Title:
Figure 4-4: Main Infrastructure Layout Changes between PEIR and DCO Application

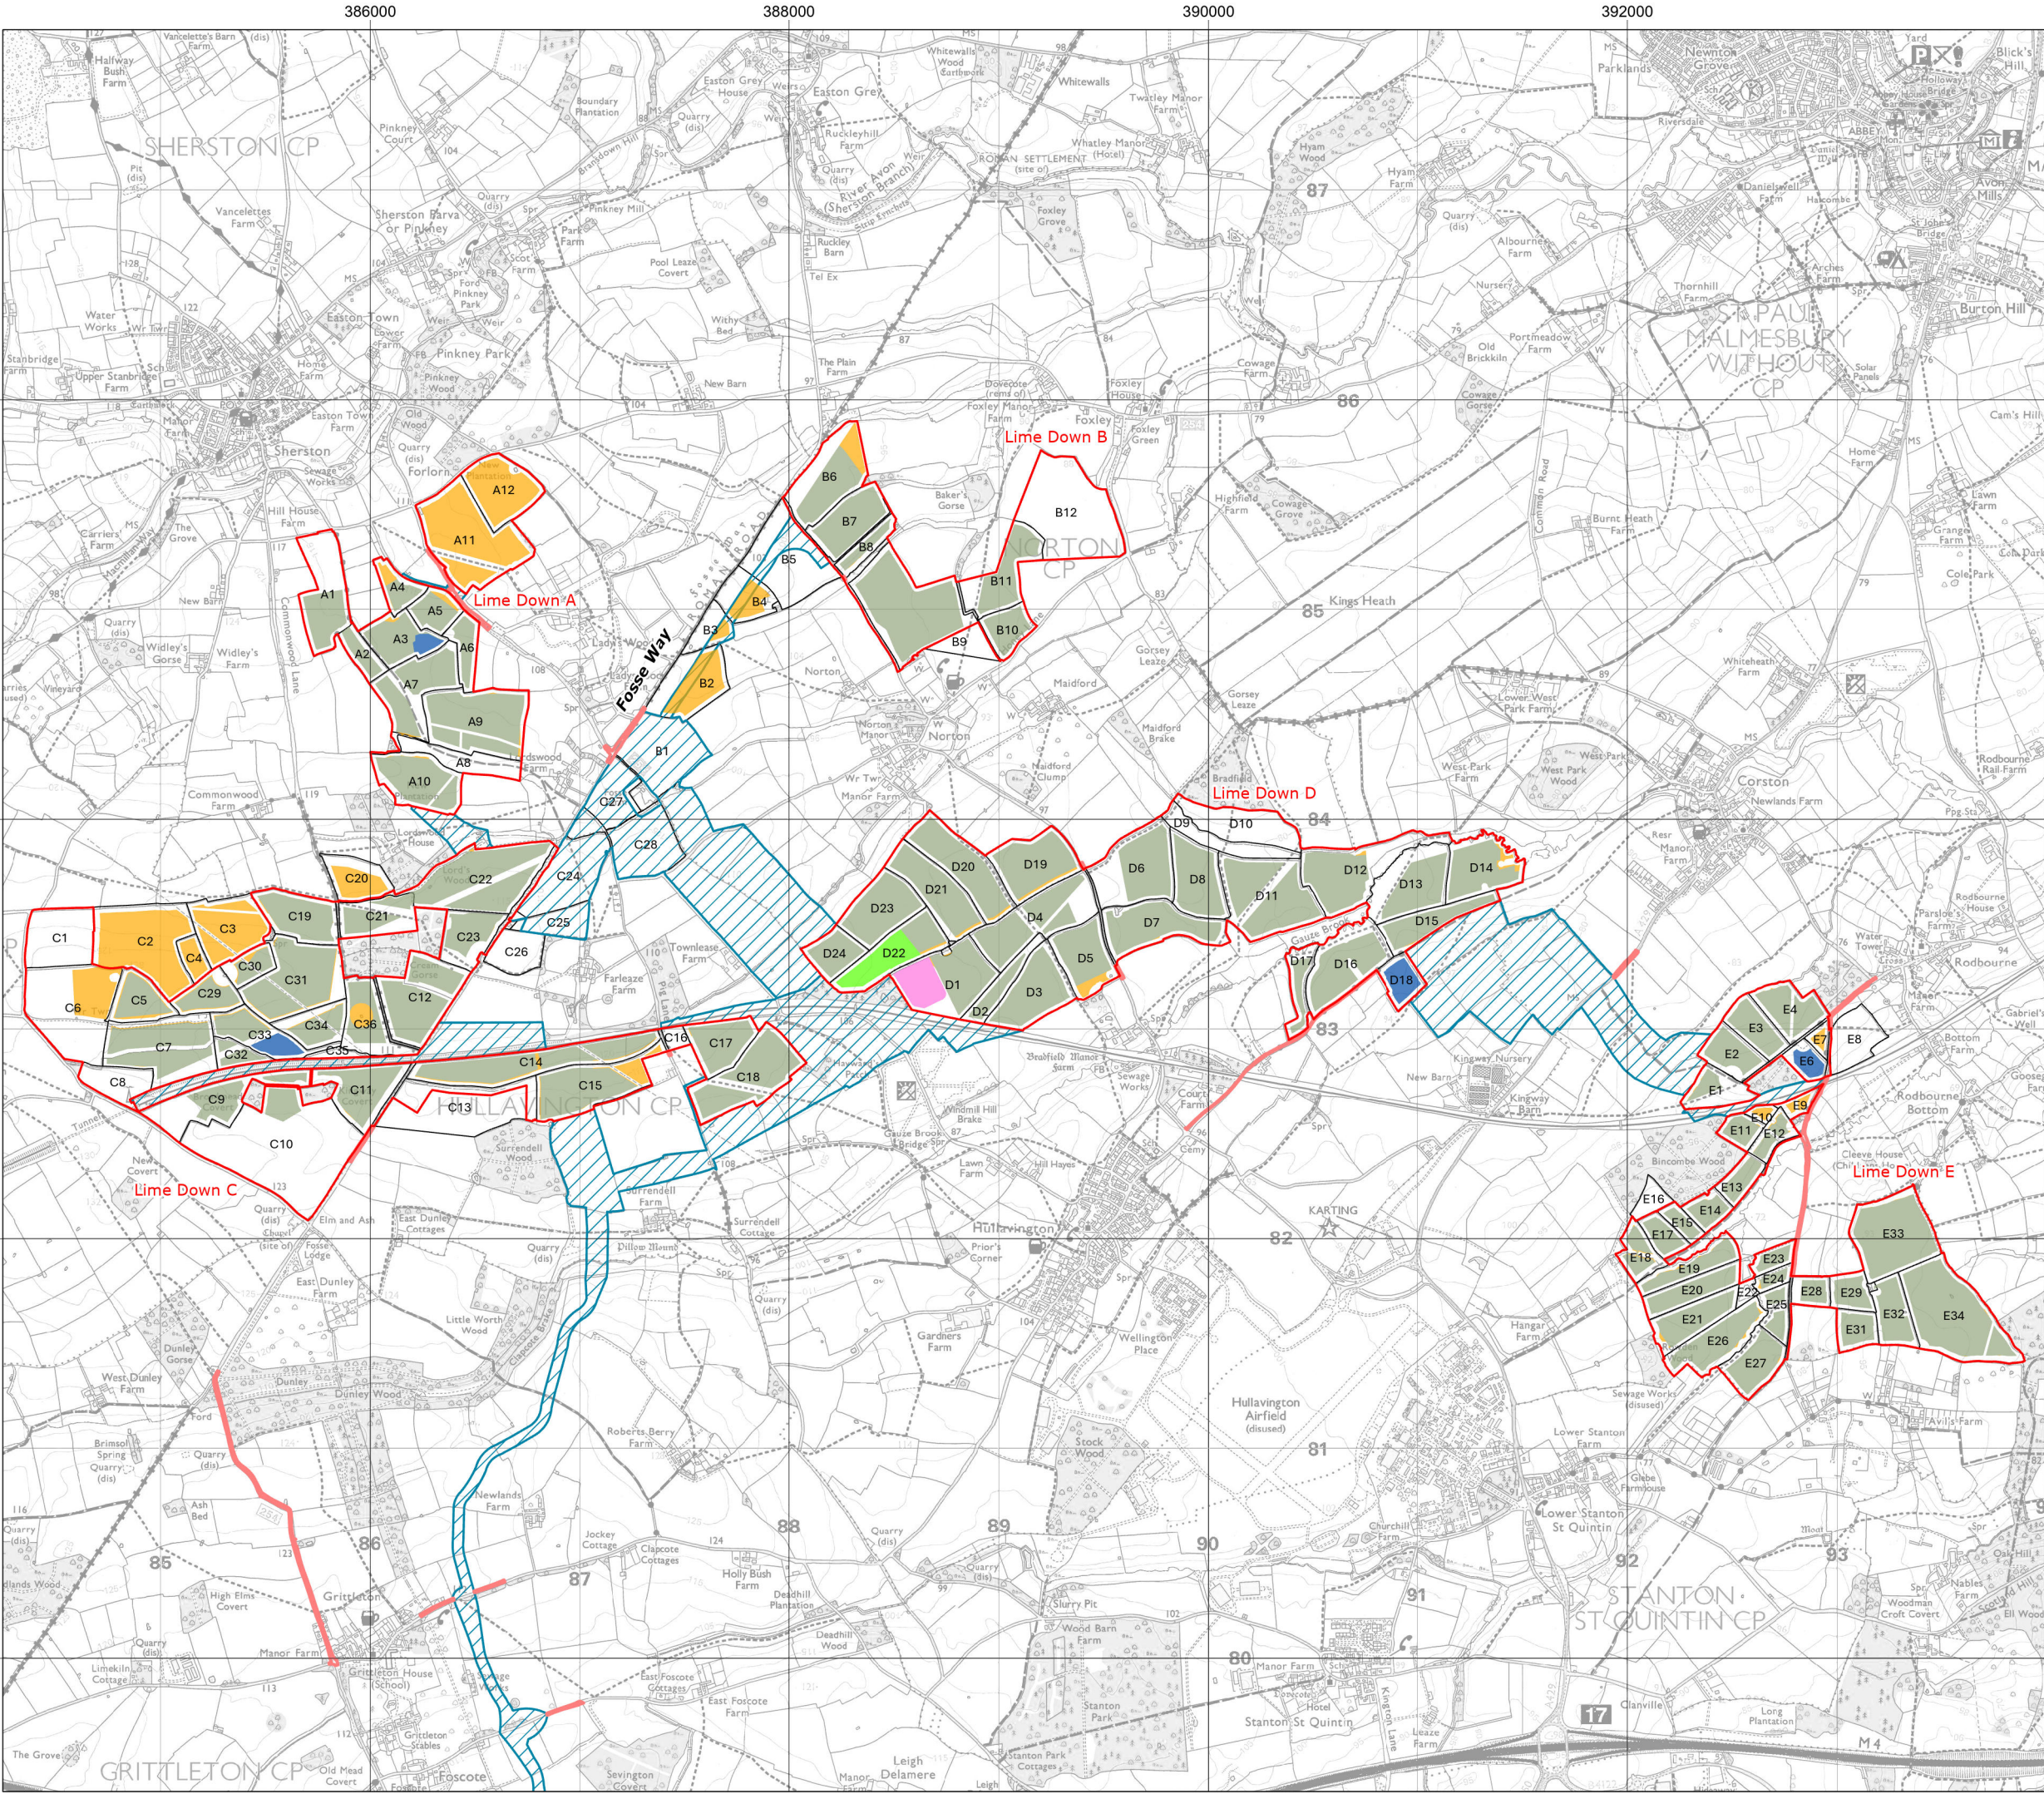
**Land and Habitat** - The Parish Council notes that the scale of the development has been scaled back along the Fosse Way and edge of AONB. However, fields A11 and A12 and half of A1 are still included within the development boundary and not removed entirely. This means that these fields will undergo a change of use which will leave them less protected from development in the future. A11, A12 and non-solar panel area of A1 should be removed from project entirely in the same way those in the central part of Fosse Way were removed.

The applicant recognises only minor/negligible short term visual effects with long term beneficial effects on biodiversity; we disagree. We recognise that the panels have been removed from A11 and A12 and also some of A1. However, the setting of Sherston as a rural village will be materially affected by the overwhelming majority of the project where the panels and infrastructure are maintained. The approach into the village from Hullavington and Grittleton will be industrial rather than rural/agricultural. Using a few fields of agricultural land for ecological mitigation of the industrial project does not seem beneficial to us. At present there is a huge variety of vegetation and wildlife within these fields and particularly within the richly biodiverse edges and hedgerows.

Furthermore, the fields along the Fosse are still going to be used for cabling whilst almost one and a half acres at the Grittleton junction end will be destroyed and used as an extra-long vehicle turning point. This area is where many local families and elderly people park to enjoy a flat and safe walk; it will be removed from them in the construction phase and returned substantially altered. The cabling will cause disturbance in the construction period and leave unsightly access panels in the long term. The applicant states that mitigation measures will reduce the visual effect over time. We would ask how long this is anticipated to take; trees and hedgerows are unlikely to cover 4.5m panels in anything under 15 years.

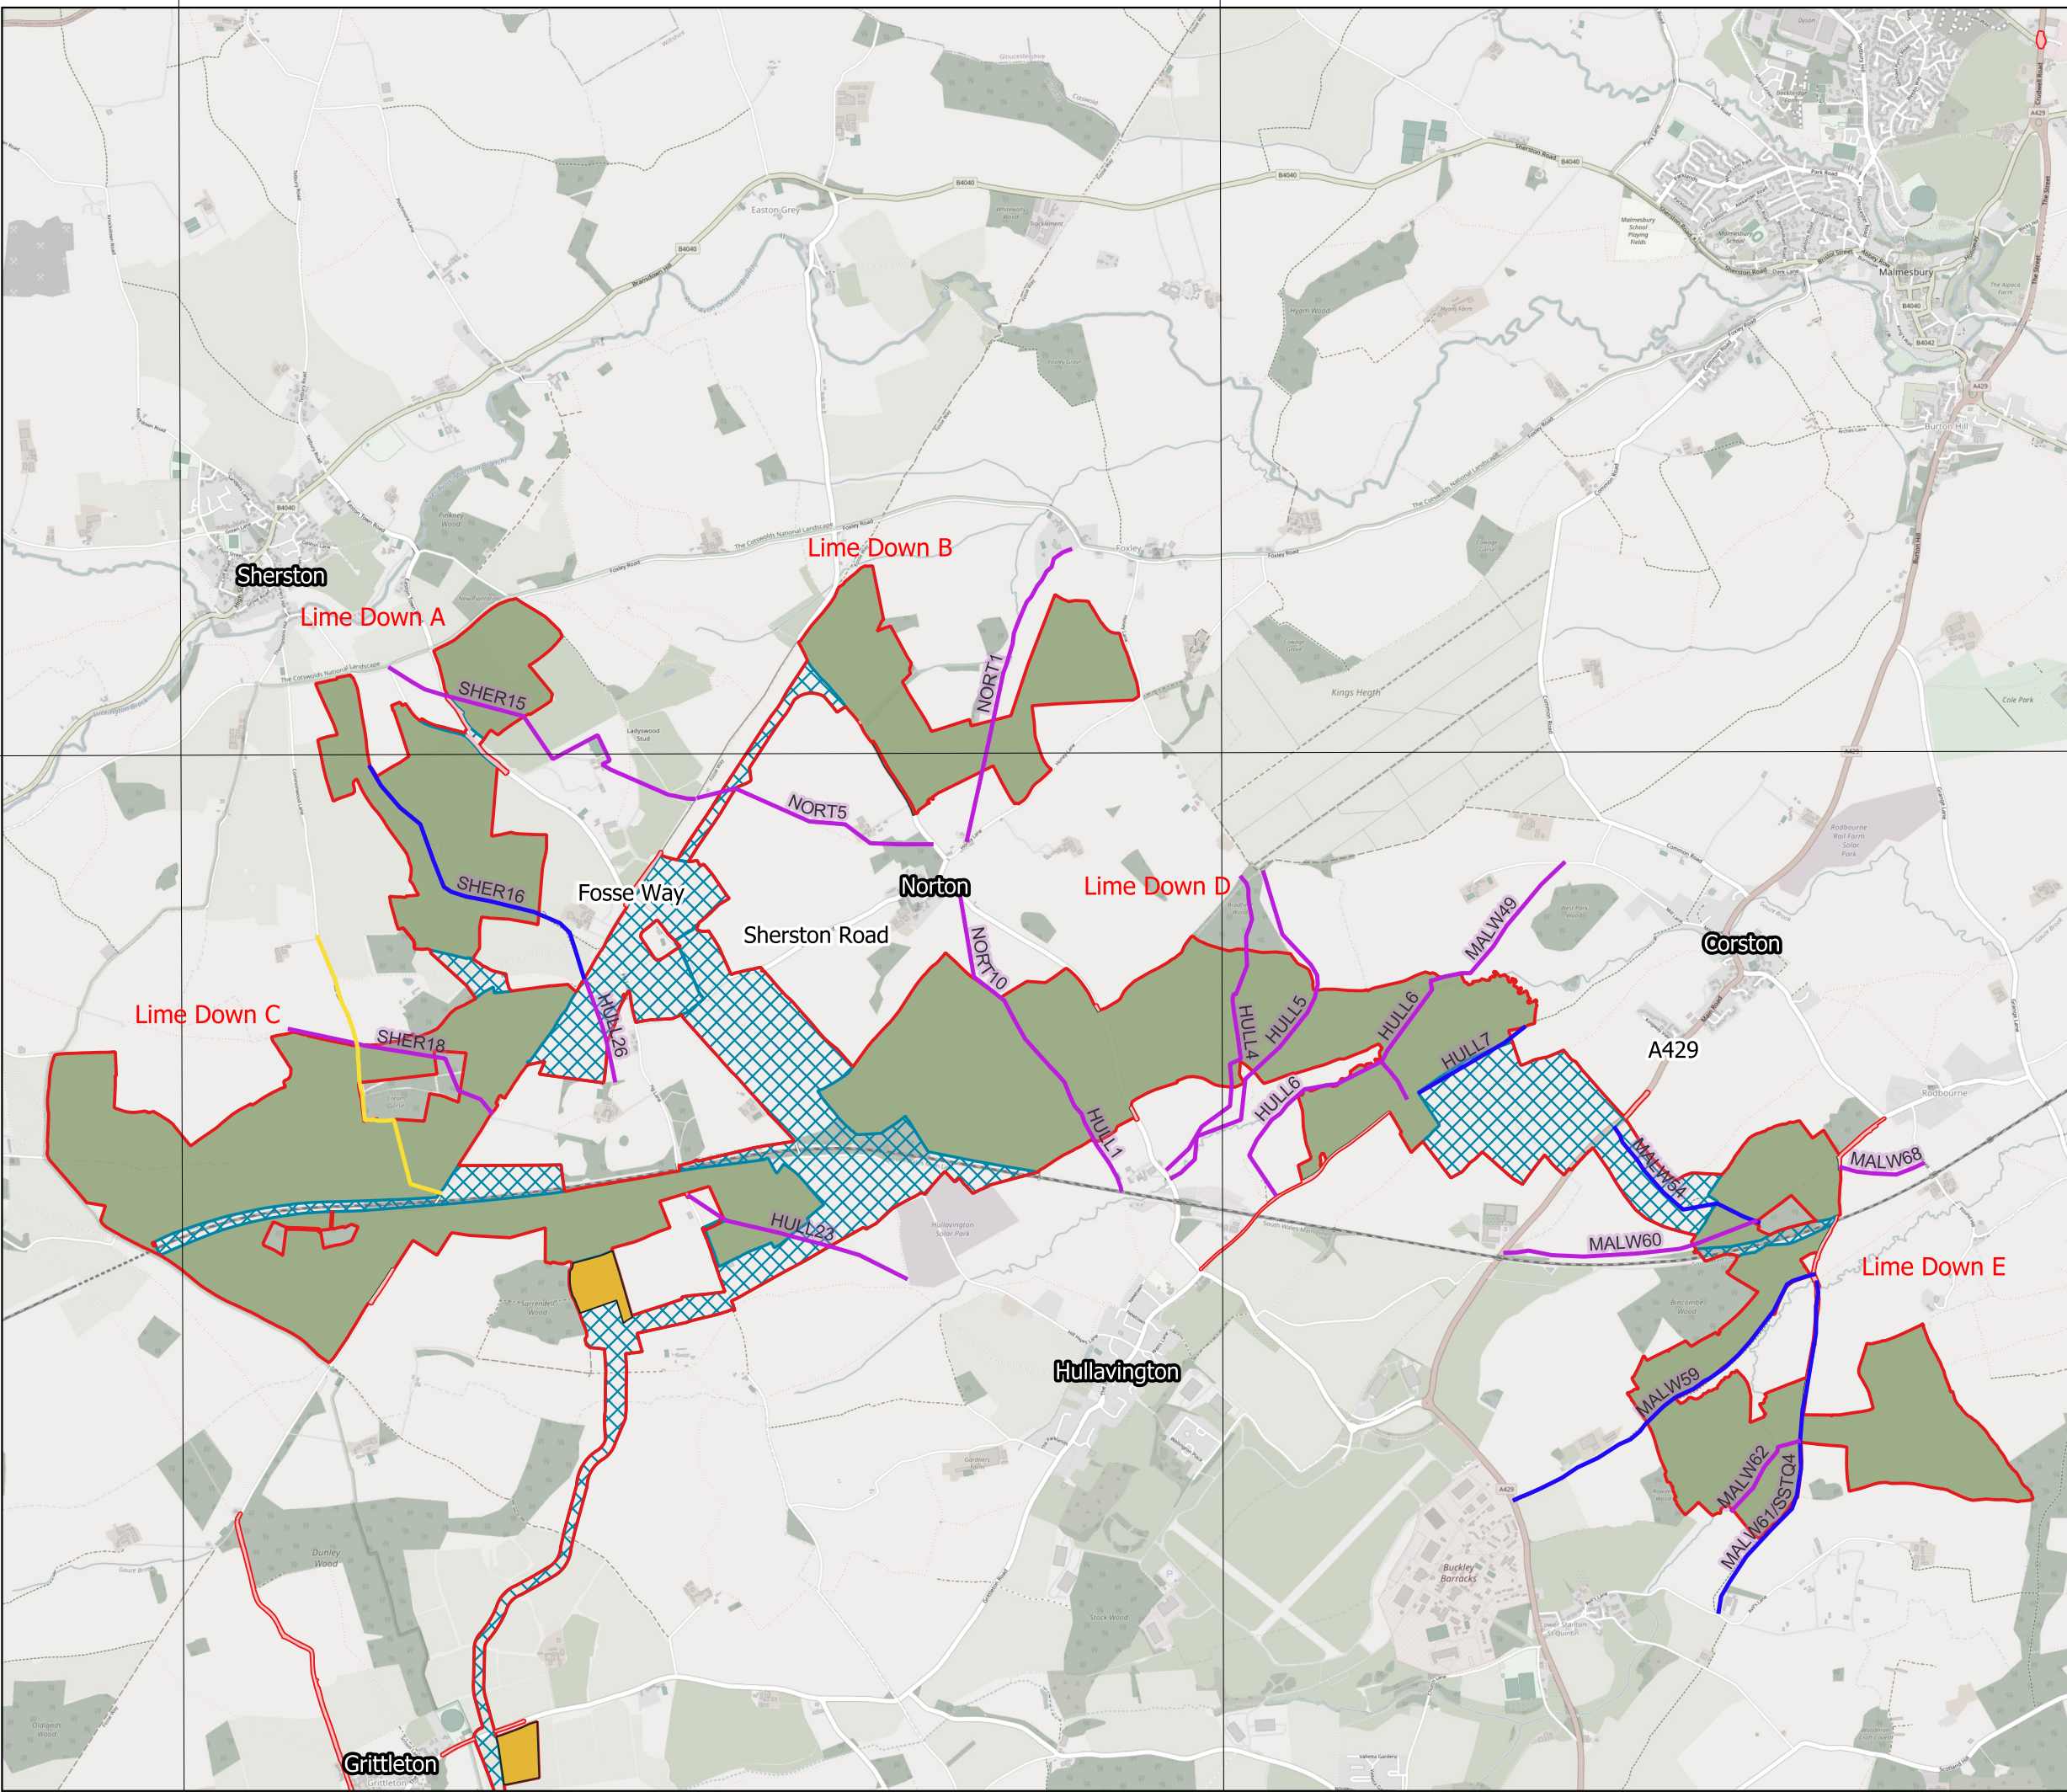
**Footpath Impact** - The applicant admits that there would be some significant effects on some footpaths. We are particularly concerned about Sherston 16, 18 and 35 which will be surrounded by panels. The footpaths and bridleways will resemble industrial tunnels. Sherston 37 will also be dramatically changed and devalued by the vehicle turning area both in the construction and post construction phase. The footpaths 11,13,14 and 15 which all start within the AONB of Sherston will be far less appealing as walkways once they lead into the industrial development of Lime Down. Walking is important to the community of Sherston. It has produced its own Sherston Walks booklet containing 10 circular walks used by many residents with upwards of 500 copies sold each year to visitors via our local business community - copy enclosed. Many of the local walks are also included in the White Walls Way publication
